Recommendation Report for Planning Permission for Works or Extension to a Dwelling

REF NO: FG/52/22/HH

LOCATION: 6 Beehive Lane
Ferring
BN12 5NL

PROPOSAL: Erection of two storey front extension with front canopy, single storey side and rear extension and extension of loft to habitable use including the installation of 1 x side dormer.

Drawing
Proposed Plans

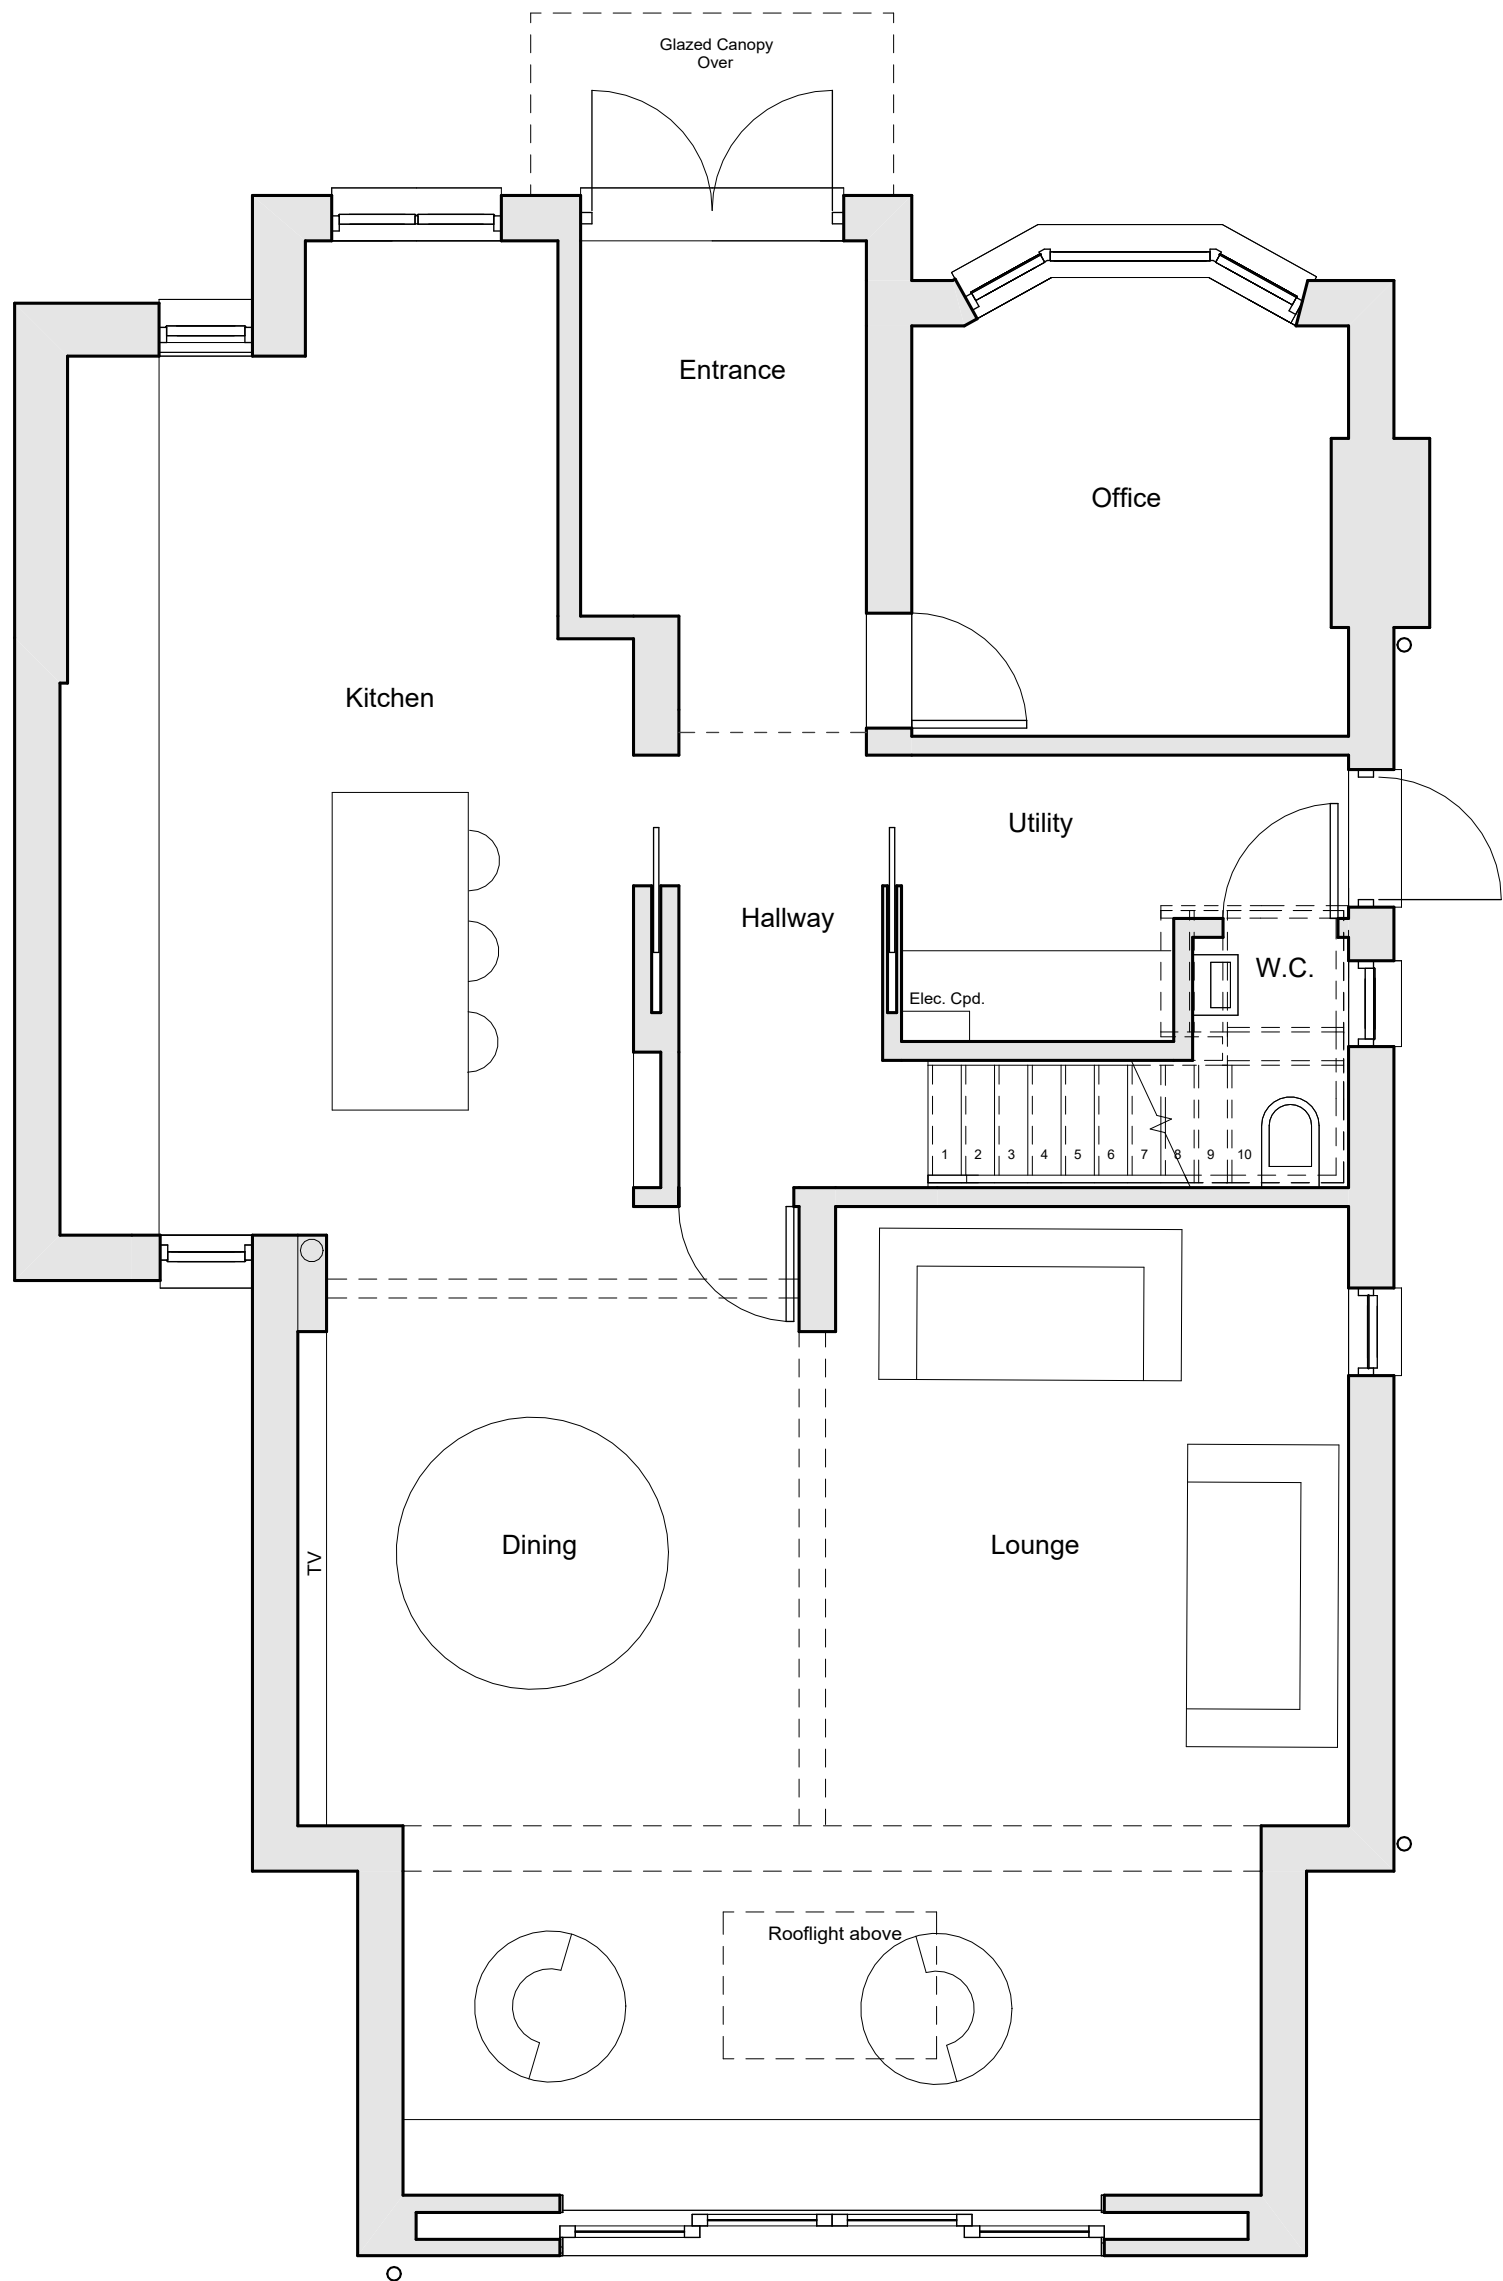
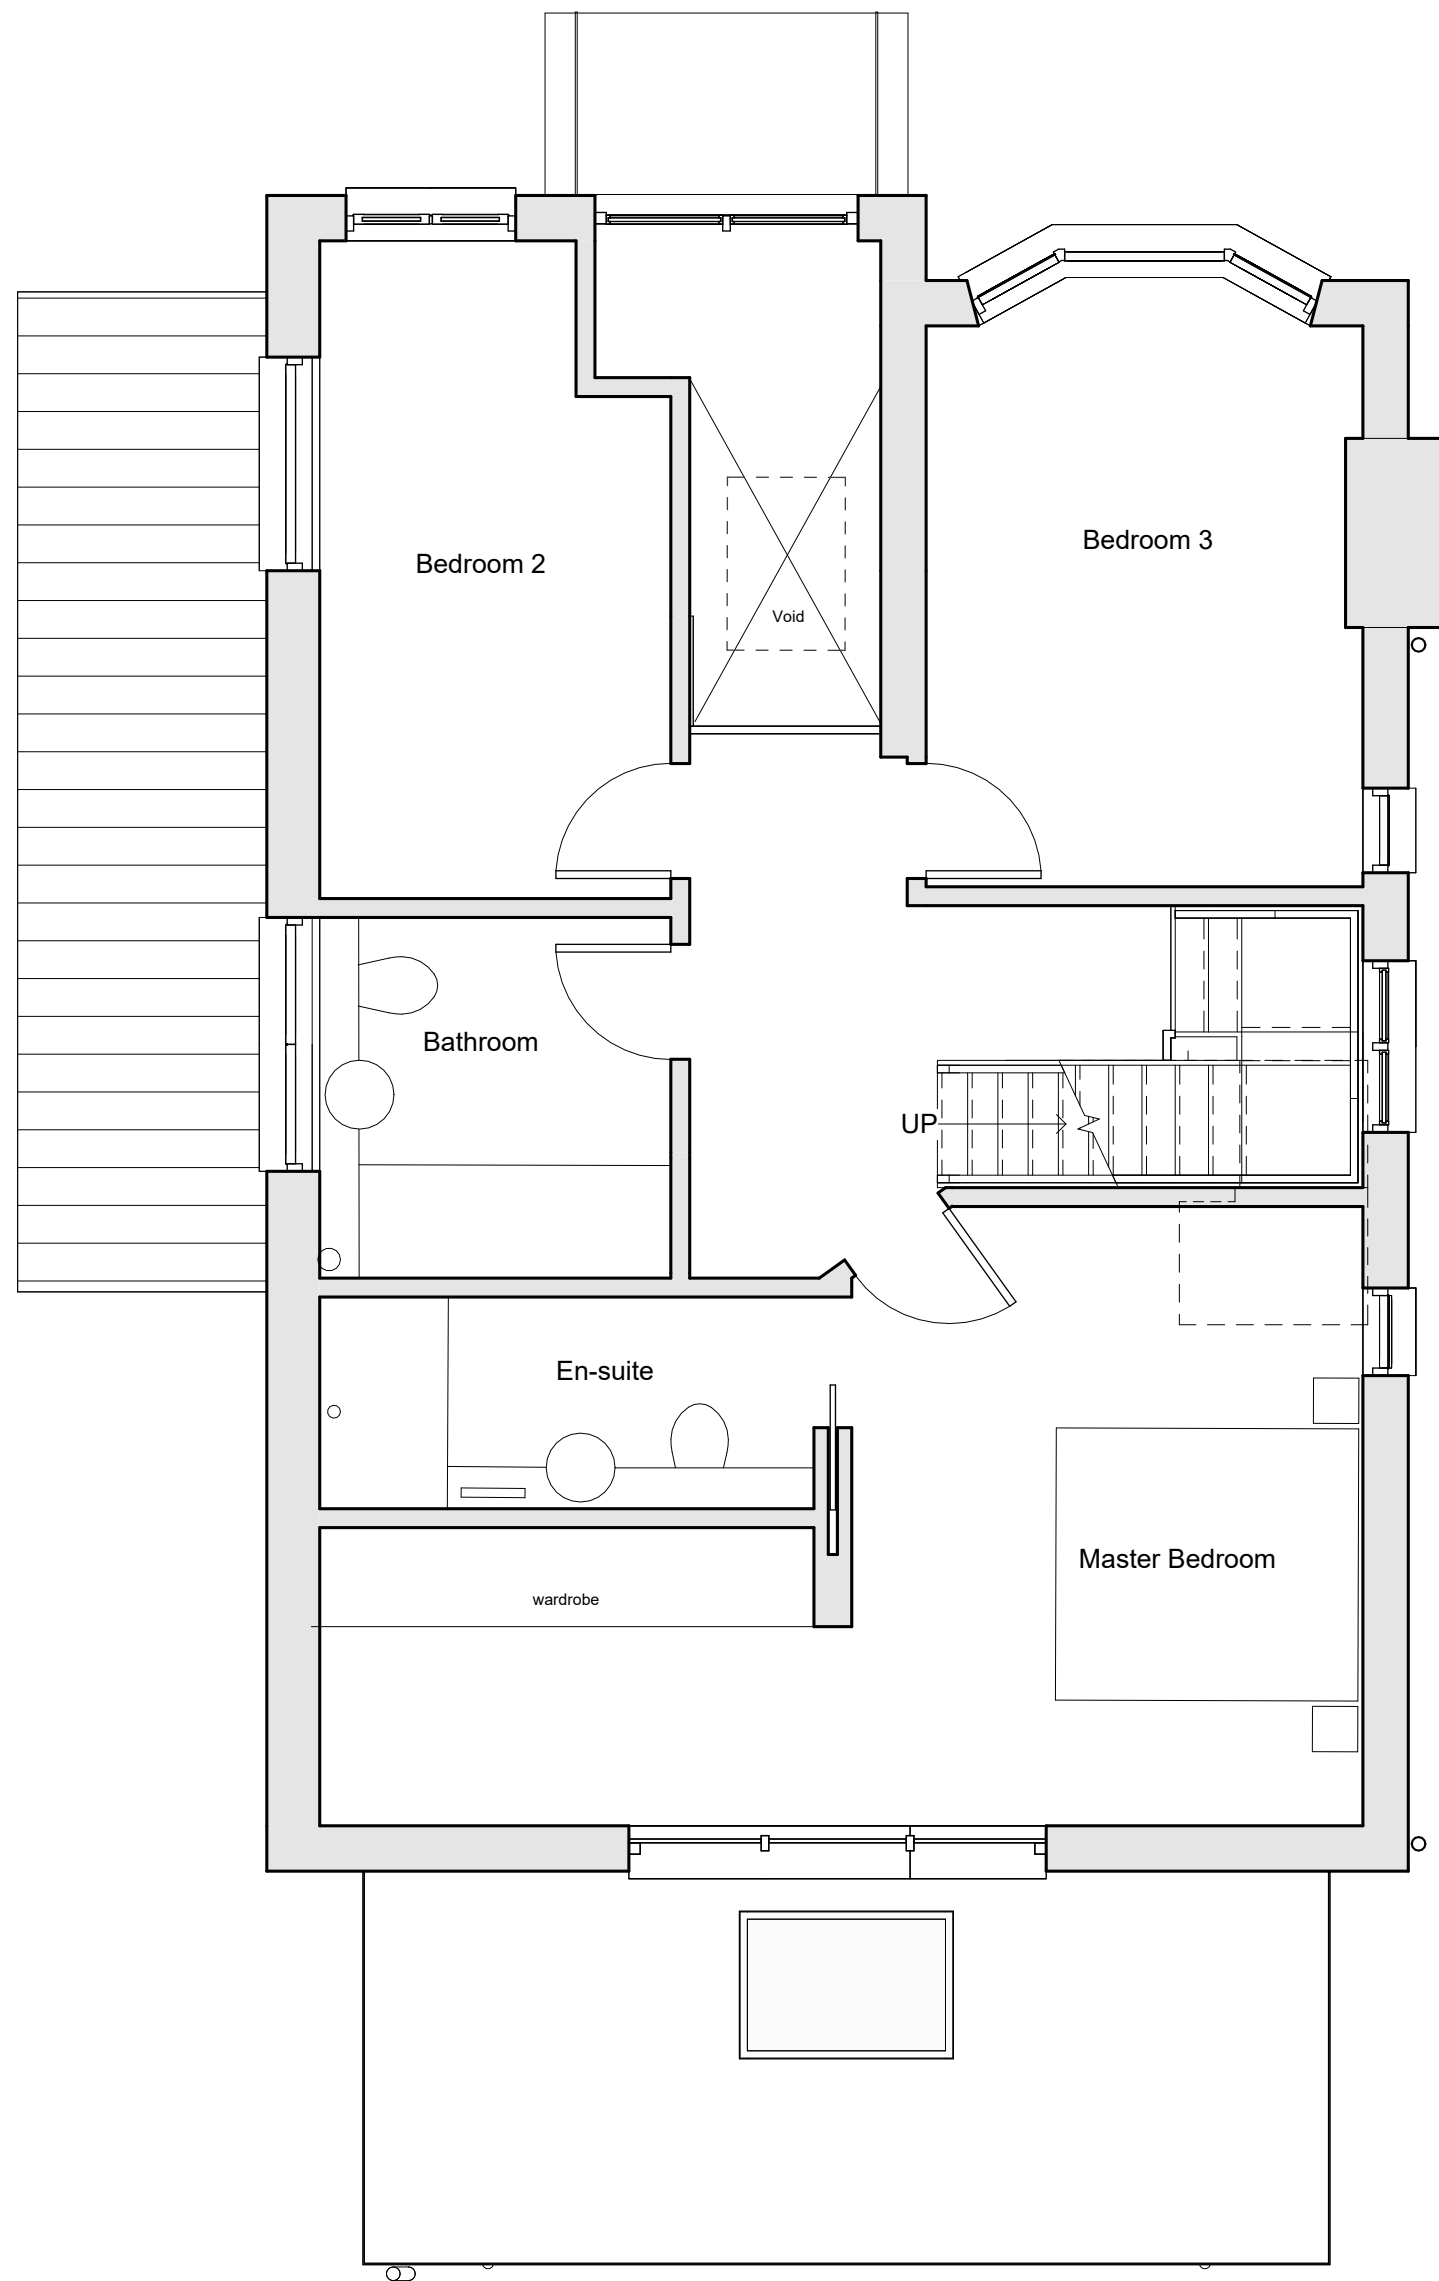
The proposed development will only encroach on the front (north) and side (western) boundaries, no development will extend past the existing line of the eastern or rear elevations. The single-storey side extension sits on the boundary with No 4A as the existing building does. To the west there is a 1.8m separation gap between the building and the shared boundary.

The single-storey side extension and two-storey front extension by reason of their location on site, orientation and scale are not considered to be overbearing or overshadow the neighbouring property to the west.

Comments have also been received regarding concerns for privacy through overlooking. No new views which are not already achievable will be created from any of the proposed fenestration located on the northern or western elevations. The roof lights to the western elevation appear to be above 1.7m from finished floor level, other windows face the public realm. The windows to the east are described within plans as obscure glazed, all other windows above ground floor levels are as existing. The glazed gable to the southern elevation has a direct back-to-back relationship with No 4 Chalet Close. The glazing at first floor level to the southern elevation will be lessening and will therefore improve the situation however, new glazing will be introduced at second floor level. This glazing replaces a much smaller rear gable which is set back by over 1.5m from the rear line of the elevation, by moving the glazing forward the 1.5m only 19m is retained between the two facing elevations, without control this would provide an unacceptable form of development. This window along with the other side windows/veluxes mentioned above will be conditioned to be non-opening and obscure glazed, to protect the privacy of all surrounding neighbours.

The first floor window to the western elevation serving Bedroom 2 shall be a non-opening and fully obscured window below 1.7m from finished floor level prior to the first use of the rooms. The window shall be retained as obscure glazed/non-openable in perpetuity.
